From: Laura Gibbons
Sent: 22 July 2019 08:34
To: Planning.Responses <Planning.Responses@arun.gov.uk>
Cc: Simon Davis <Simon.Davis@arun.gov.uk>
Subject: RE: Planning Consultation on: AL/51/19/PL

Engineers Comments Regarding Surface Water Drainage

APPLICATION NO: AL/51/19/PL

Description of Works: Demolition of the existing dwelling & erection of 3 No 2-bed, 3 No 3-bed & 4 No 4-bed dwellings, access, landscaping & associated works.

Fig 7 - Proposed Site Layout Plan

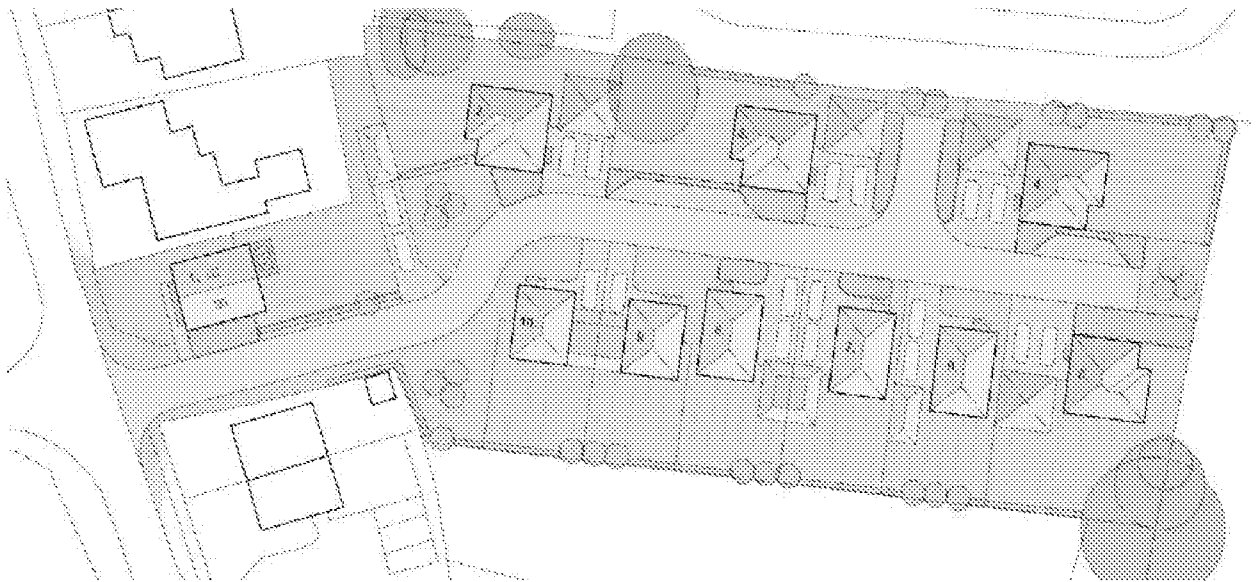
There is an ordinary watercourse along the northern boundary, all houses and fences/ walls must be kept 3m from the top of bank of this watercourse.

No consideration has been given to surface water drainage, prior to determination please can the applicant submit a strategy for surface water drainage to demonstrate that the development will be able to drain with the proposed layout. This strategy should acknowledge that infiltration will be investigated and that winter groundwater monitoring and winter infiltration testing will be completed. However, a worst case scenario drainage strategy should be submitted to show how the site could be drained, this could assume ground water at surface and no infiltration. Please note ground raising and pumping are not sustainable solutions and will not be supported.
